OFFICIAL NOTIFICATION OF DECISION

Project# PR-2020-003484
Application#
**SD-2024-00158 – EXTENSION OF PRELIMINARY
PLAT**

For all or a portion of
**Lots 2 & 3, Block 12 Unit 3, VOLCANO
CLIFFS SUBD** zoned **R1-D** located on **Mojave
Street NW between Unser and Tesuque**
containing approximately **4.25** acre(s).
(L-10)

**MOJAVE SUBDIVISION**  
 GRADING AND DRAINAGE  
 GRADING PLAN

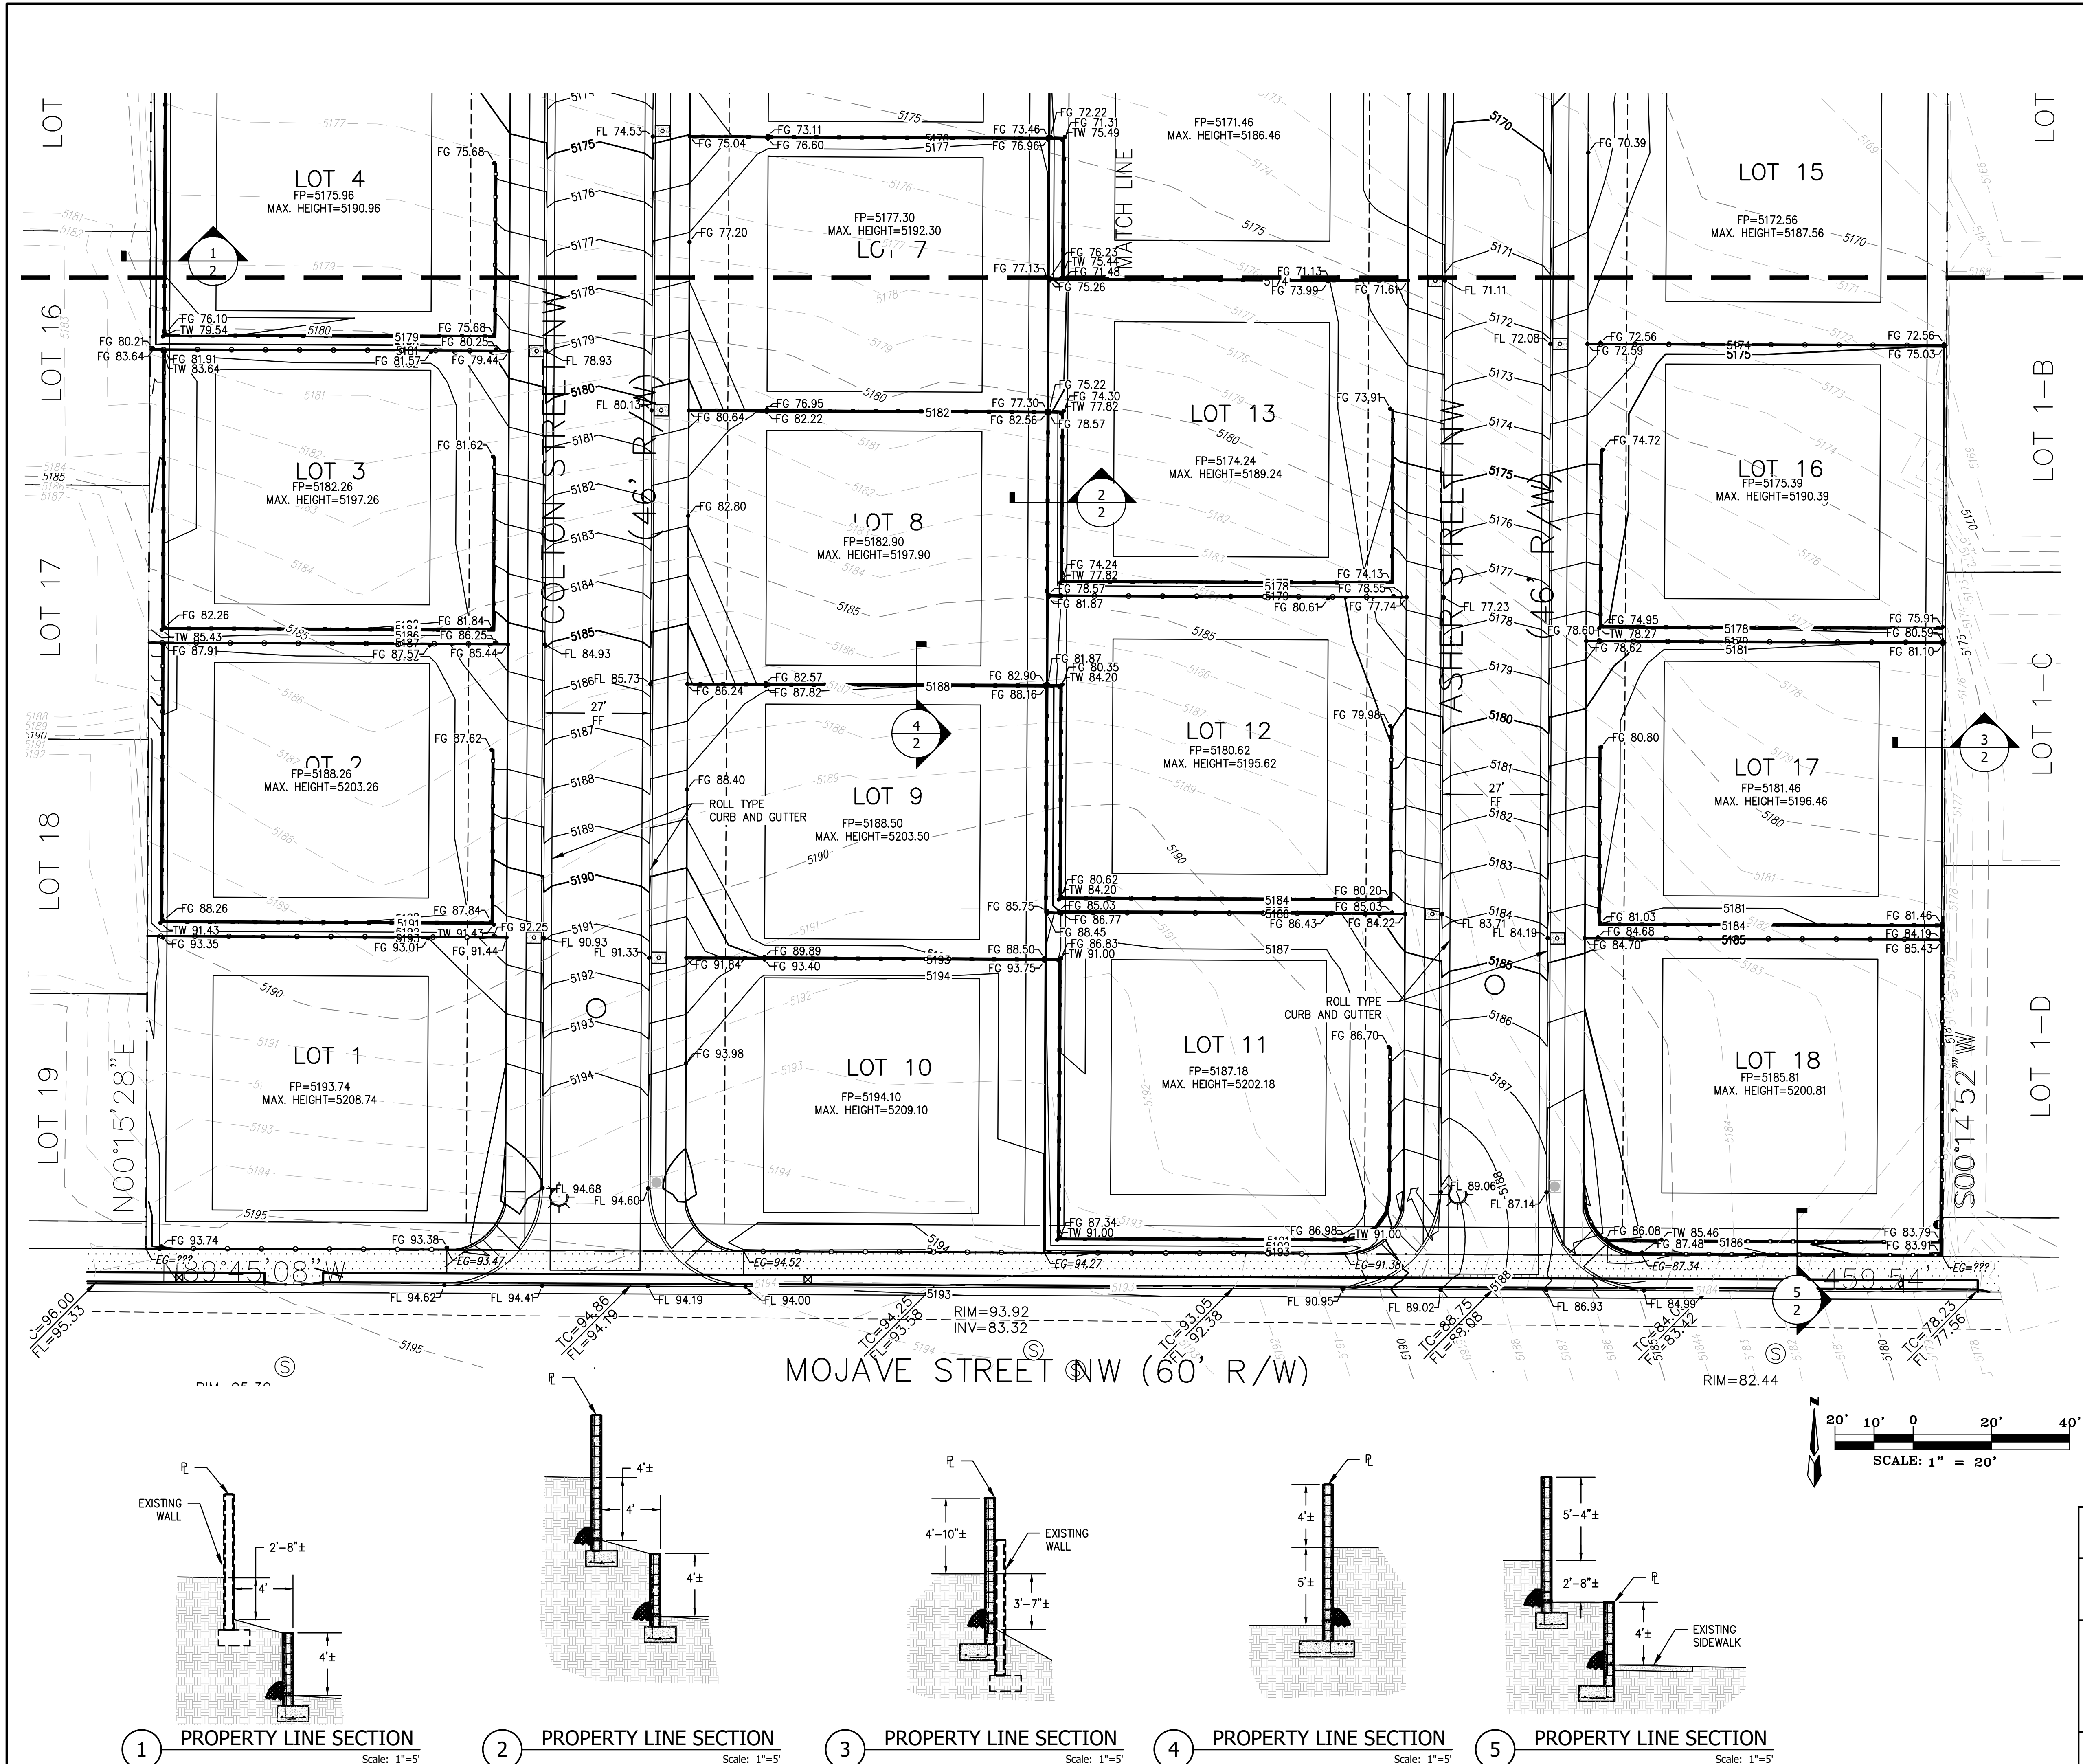
8. The Applicant will build a scour wall 6 feet away from the northern property line and on the private parcel to retain stormwater on site and protect the MPOS. All development near the MPOS boundary including the scour wall shall be constructed to have the least amount of disturbance to any Major Public Open Space land. Any disturbance shall be addressed and mitigated in compliance with the IDO section 5-2 and the Standard Specifications outlined in Section 1014: SENSITIVE LANDS PRESERVATION AND CONSTRUCTION MITIGATION. When the Buffer Protection Zone is along the MPOS edge, any plantings or development must follow the site plan and associated grading plan. It is recommended that a temporary construction fence be erected to mitigate any and all disturbance on MPOS/Monument property prior to grading and construction work.

9. The grading plan complies with IDO 3-6(E) for parcels within the VPO-2 Height Restricted Sub Area, wherein, 'Building and/or structure height shall not exceed 15 feet, as measured from natural grade.' The Applicant has shown height measurements from finished grade and natural grade and established maximum building heights that do not exceed 15 feet.

PRELIMINARY PLAT FOR
MOJAVE RIDGE SUBDIVISION
(A REPLAT OF LOTS 2 & 3, BLOCK 12,
UNIT 3, VOLCANO CLIFFS SUBDIVISION)
WITHIN
SECTION 27,
TOWNSHIP 11 NORTH, RANGE 2 EAST, N.M.P.M.
CITY OF ALBUQUERQUE
BERNALILLO COUNTY, NEW MEXICO
JANUARY, 2023

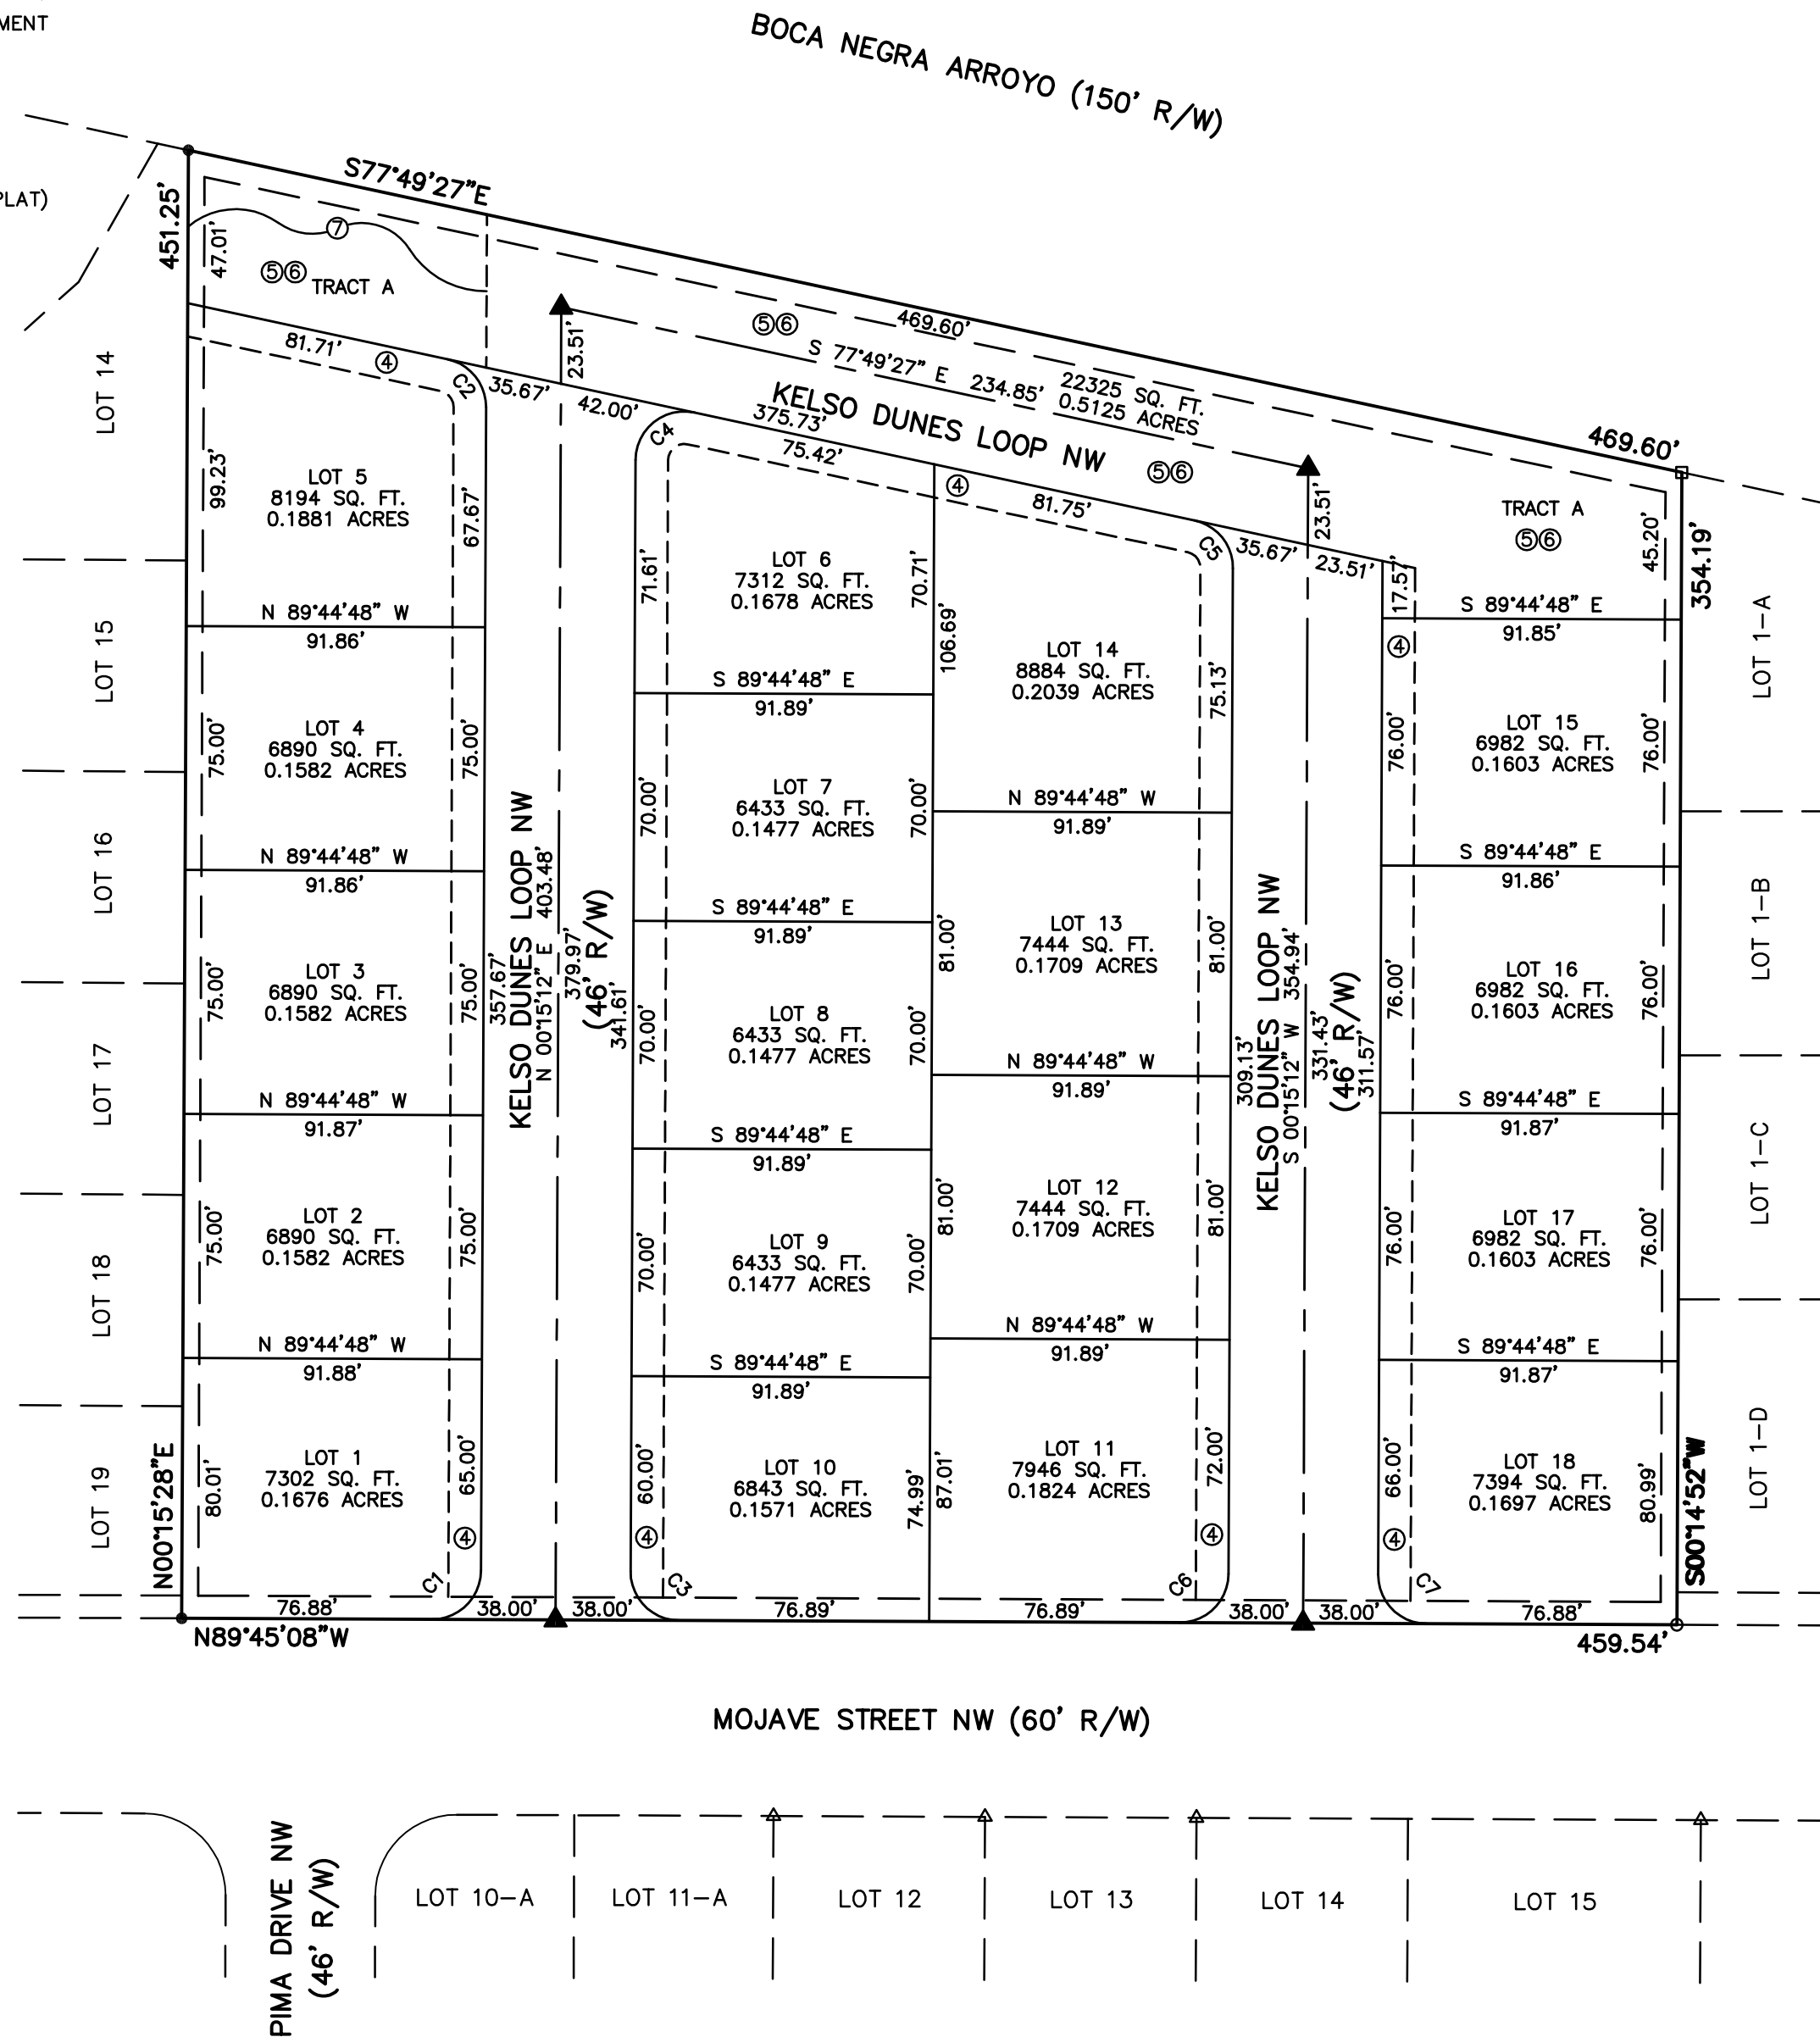
7. The subdivision complies with the IDO requirements of 5-2(J)(2)(a) for subdivisions abutting Major Public Open Space by means of a 47-foot-wide tract along the property's northern boundary. The Plat shows that the westernmost portion of Tract A to a dotted line is an open space buffer. The easternmost portion of Tract A is a drainage pond. Both of these areas must have plant material approved by the Superintendent of Open Space. The middle, and longest portion of Tract A, is a single-loaded street.

- b. Add a note on the Plat that the parcel adjacent to the subject site "Boca Negra Arroyo (150' R/W) is zoned NR-PO-B for MAJOR PUBLIC OPEN SPACE - PETROGLYPH NATIONAL MONUMENT."

- c. Revise the Infrastructure List Notes on Drainage to state 'City Standard Specification 1013.' Add a note to the Plat indicating DHO approval of the determination to retain a 60-foot Right-of-Way on Mojave Street.
- d. City Engineer must approve the Erosion and Sediment Control Plan addressing the sensitive lands issue to the north and that sheet must be approved by the City Engineer prior to any grading and drainage on the site AND prior to the Final Plat application.
